# SCH STAGE 1 / CCCC

## PUBLIC DOMAIN & LANDSCAPE

### RESPONSE TO SUBMISSIONS REPORT

SSD-10831778  
14 September 2021  
APPENDIX No. 01

Level 04 Landscape Plan

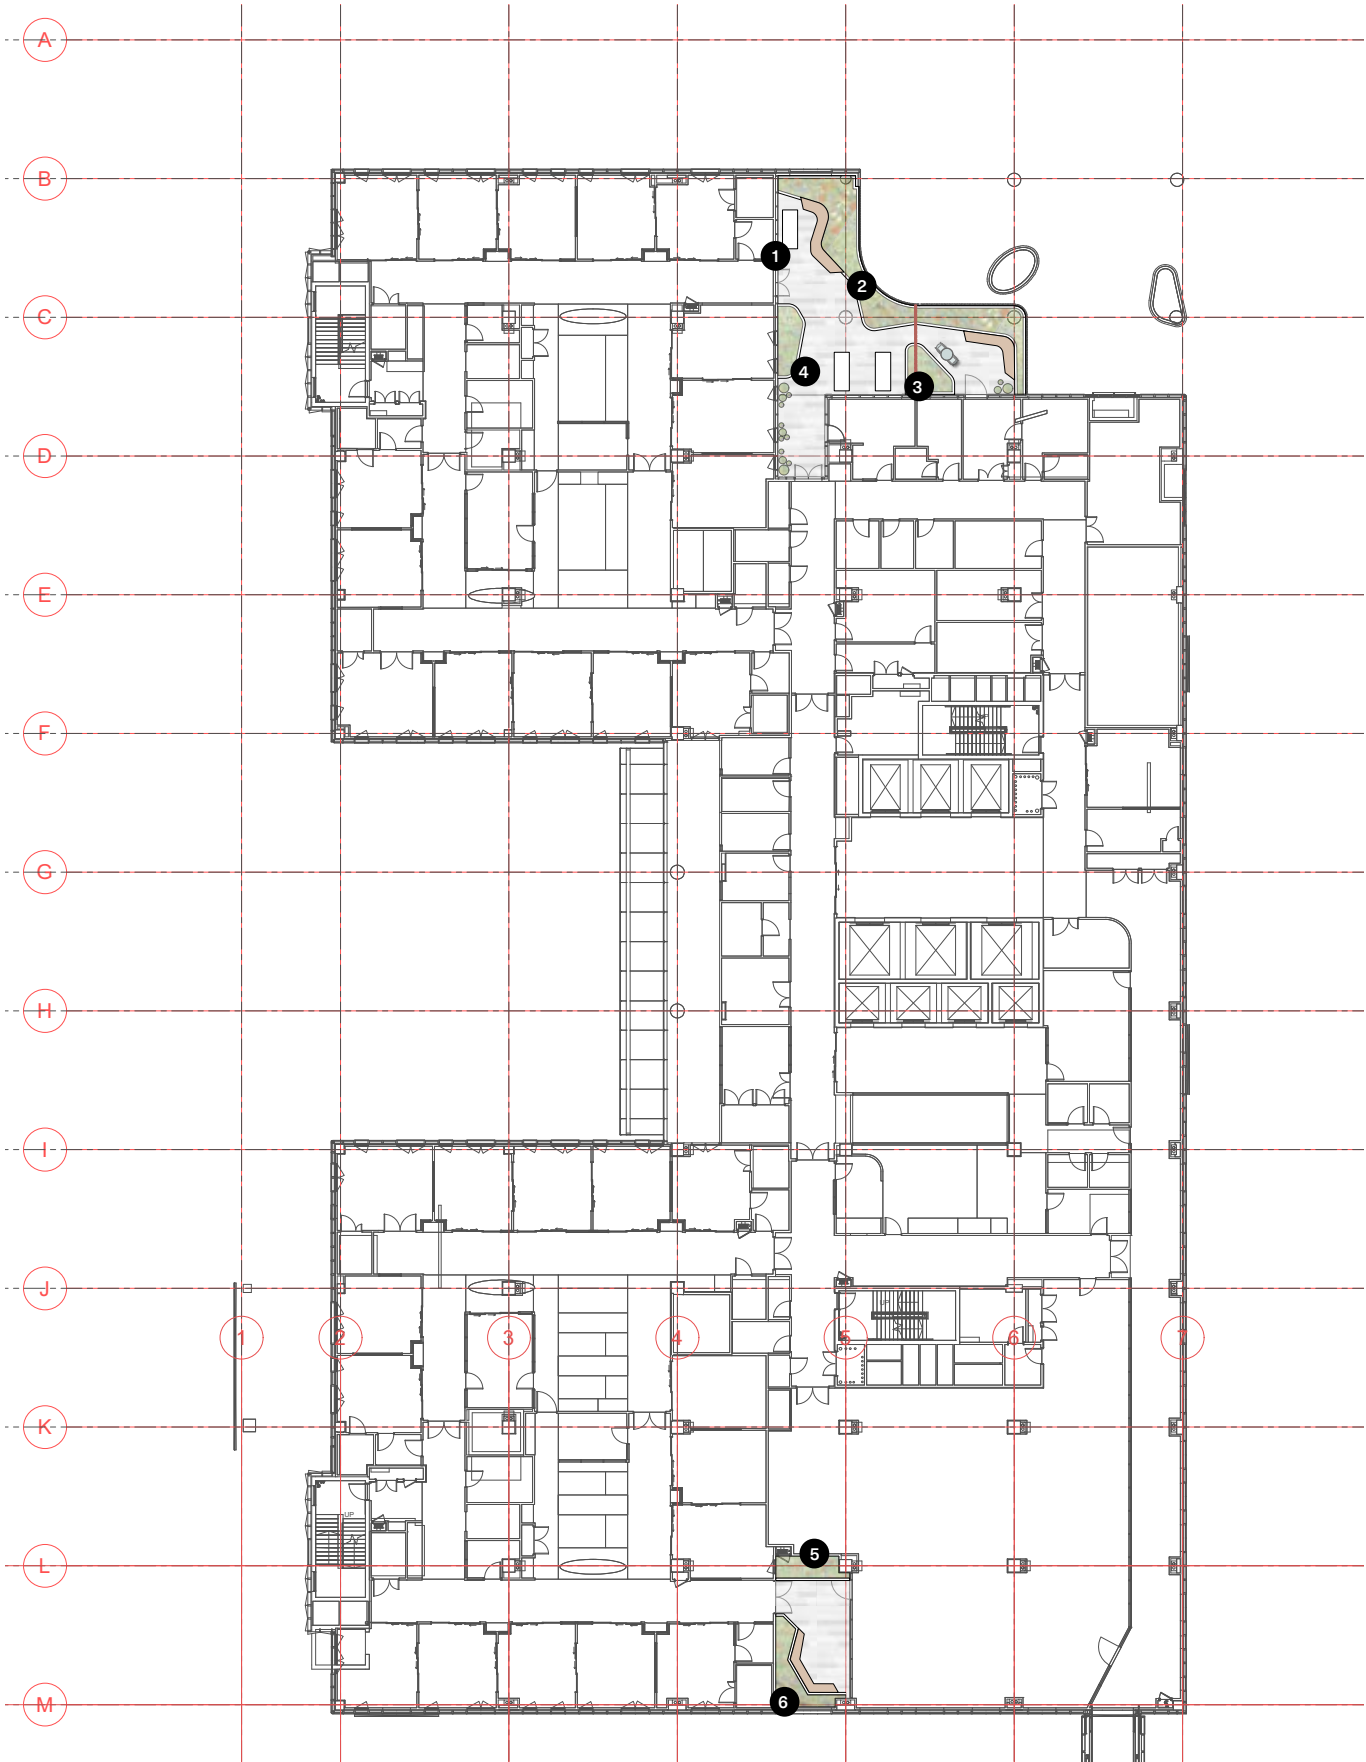
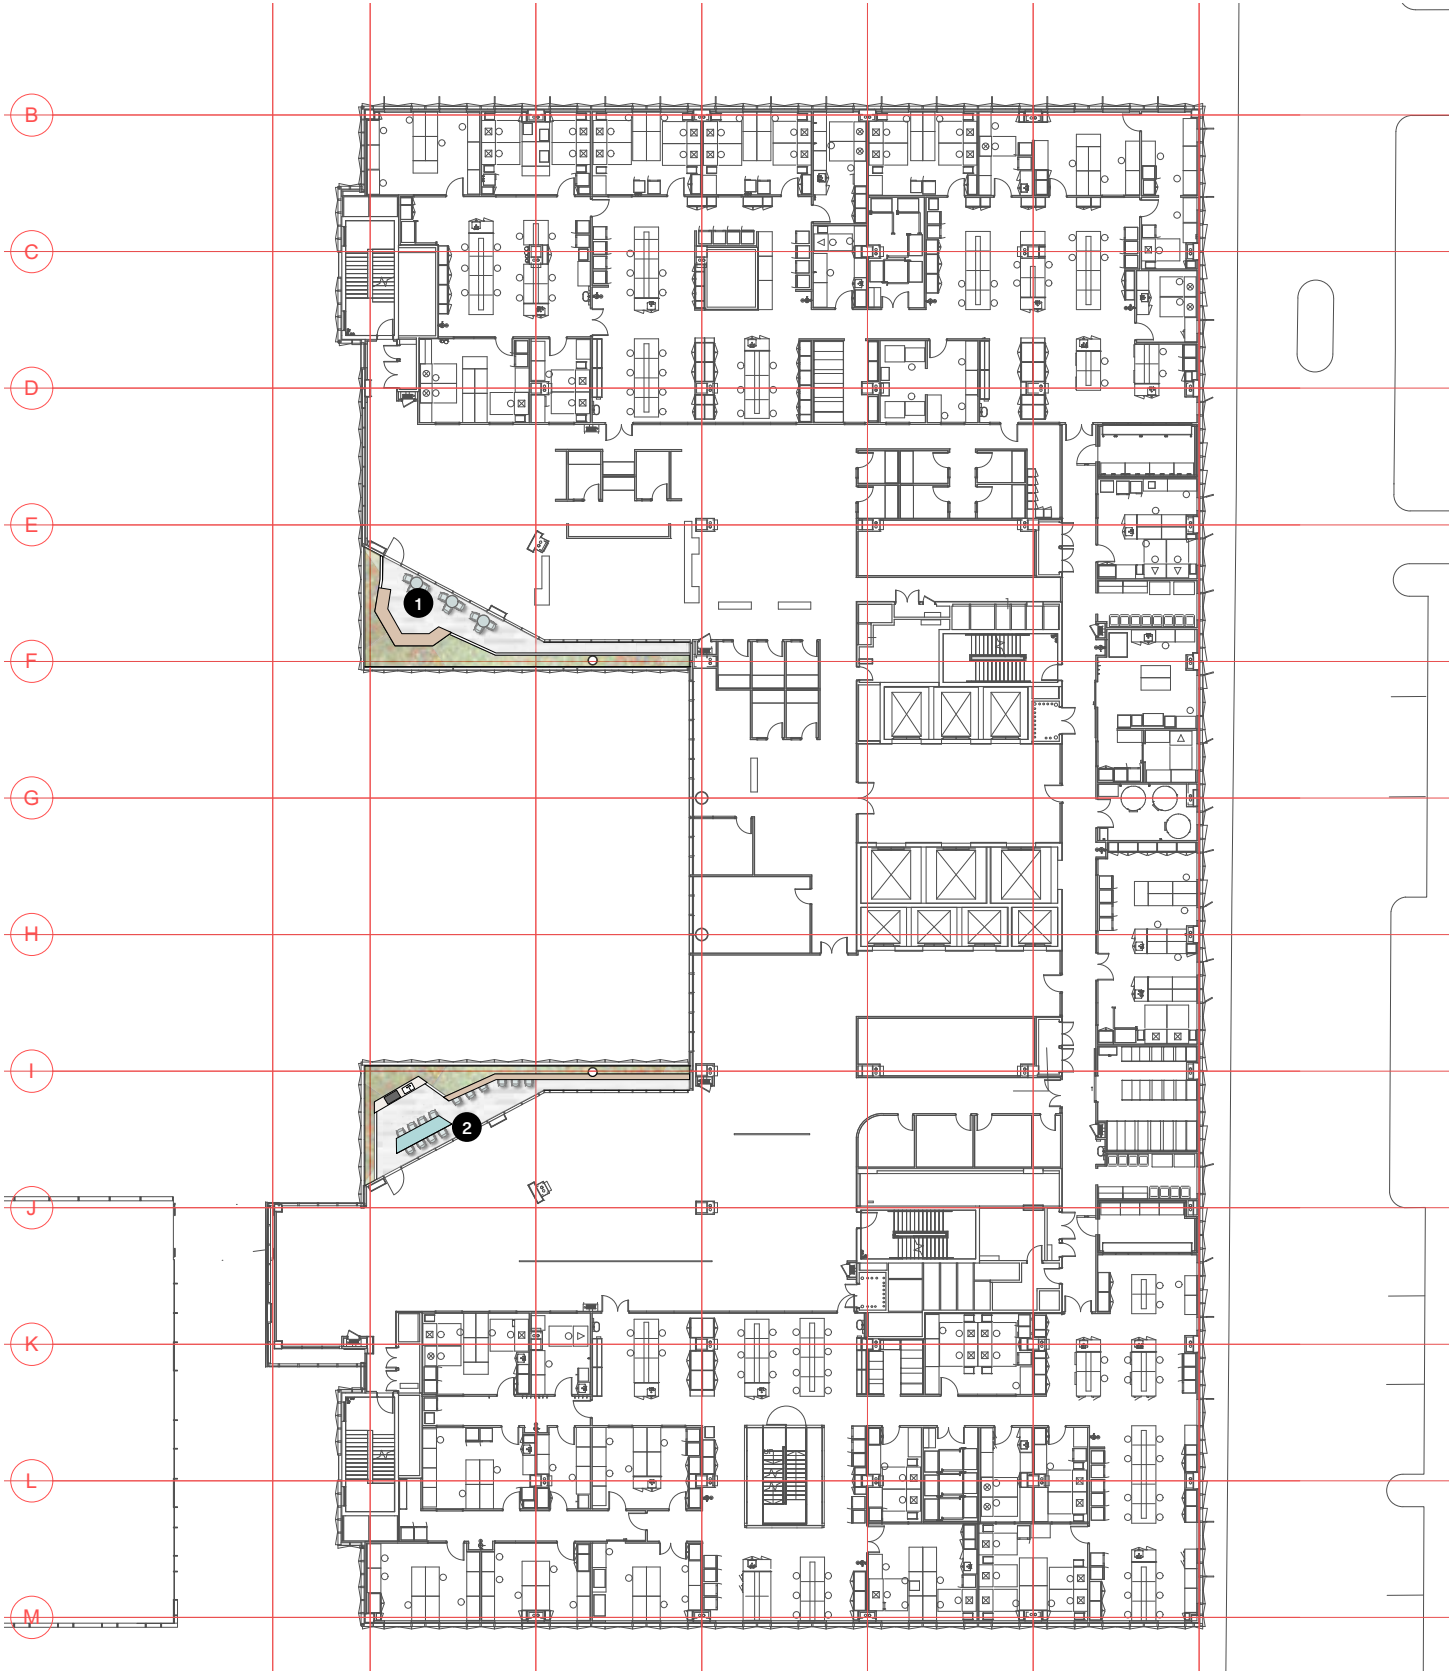
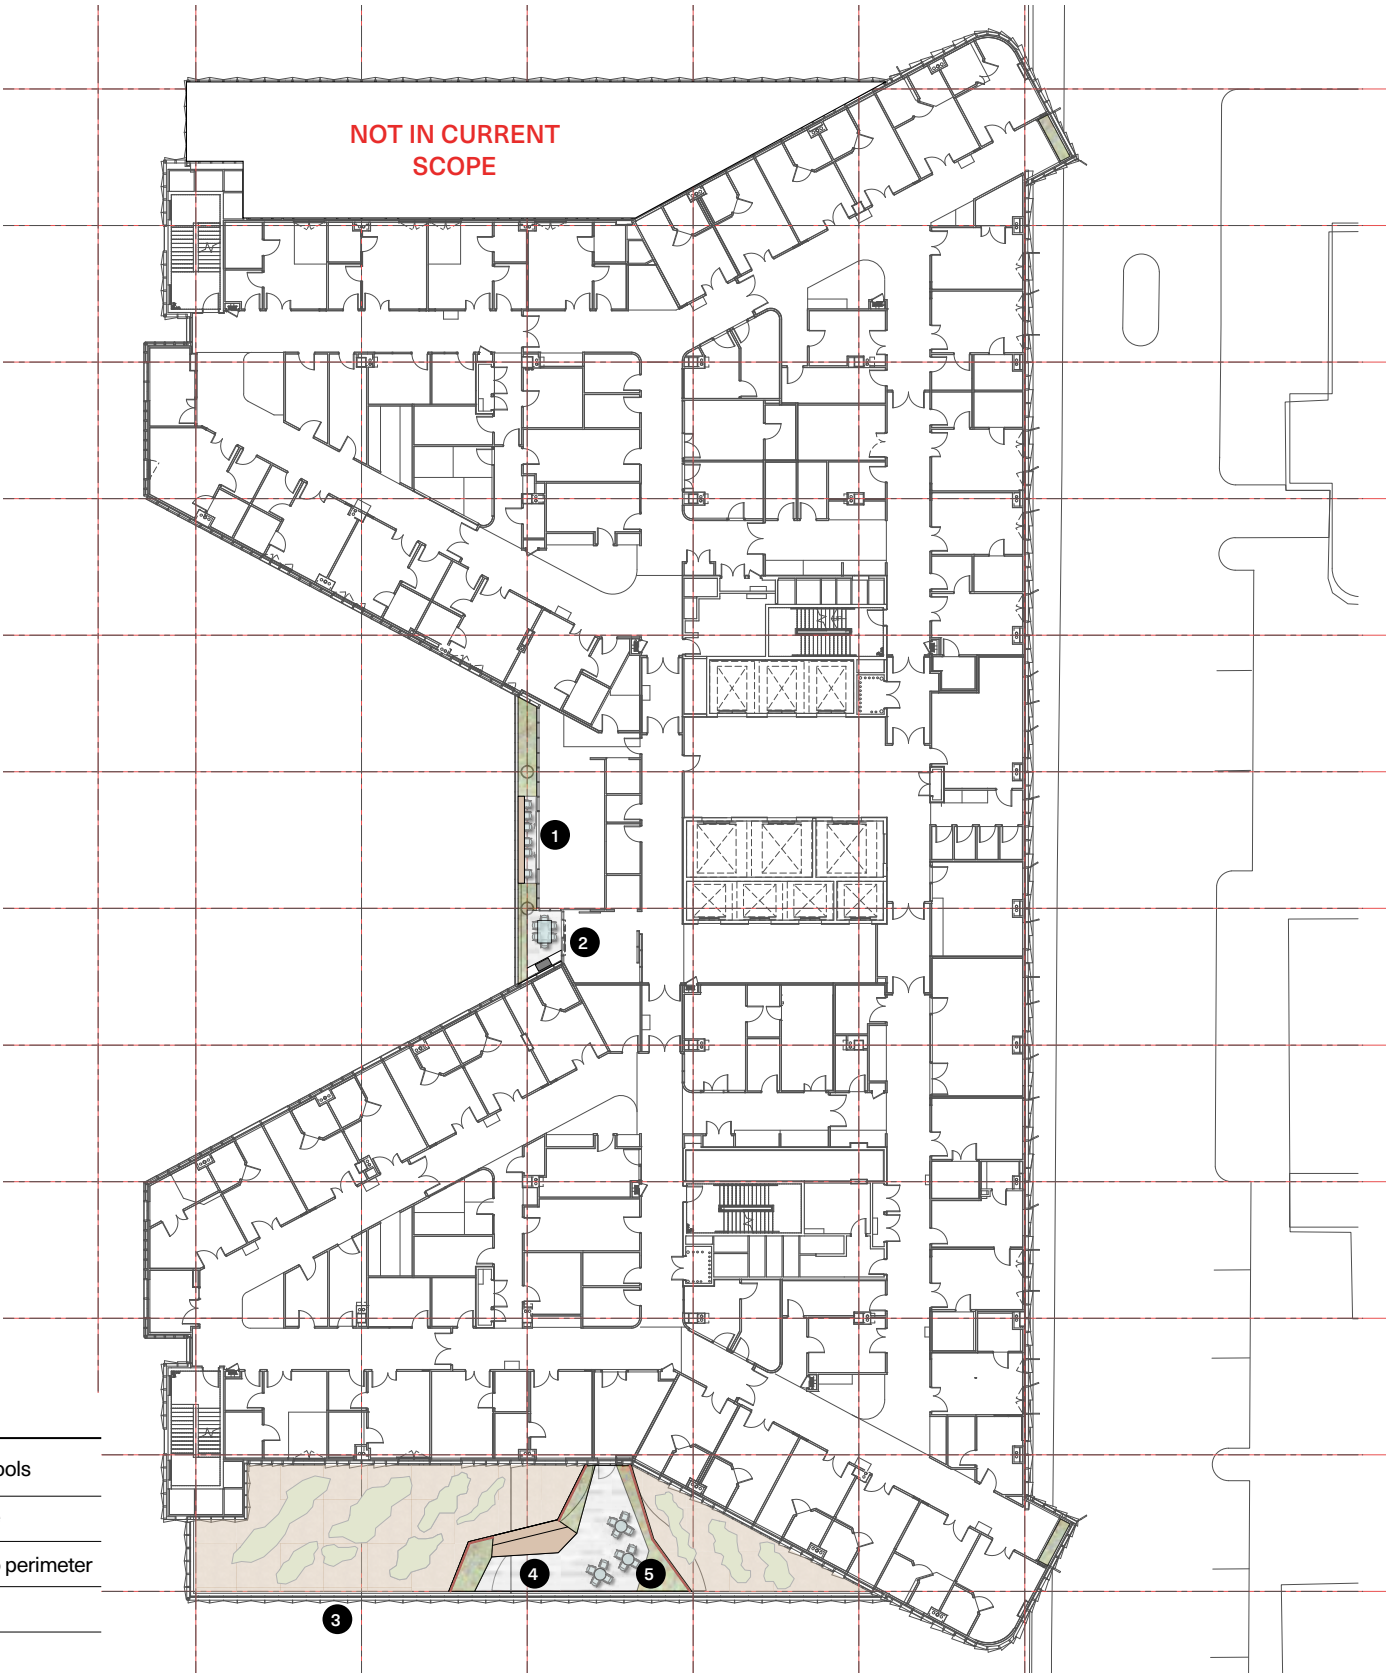
Visualisations indicate landscaping to upper levels terraces and utilisation of podium roof areas for landscaping but no details are provided on the landscape plans. Landscape plans should be updated to include these areas and demonstrate provision of high quality outdoor spaces for occupants of the building and to assist with offsetting any shortfall in tree canopy cover.

Further landscape detail is required for the proposed roof level and upper level terraces as the building form steps back. The podium roof areas should be utilised to provide outdoor landscaped terraces areas for patients, visitors and workers where possible.

The design team has included additional reference to the upper level terraces for levels 1, 4, 5, 6, 7, & 8, including the landscape plans as part of the updated landscape drawings. These series of accessible and inaccessible landscape spaces provides opportunities for patients, staff and visitors to experience the biophilic benefits of being in contact with plants and natural systems on a day-to-day basis.

This also includes a developed facade planter approach between levels 5 & 8 to create a green outlook both from within the buildings and viewlines from the public plaza.

The design team has updated the outdoor terraces to illustrate extent and use of these spaces. This includes a series of accessible and inaccessible spaces that allow for patient, staff, and visitor respite, engagement and enjoyment and will be developed further during DD stage.
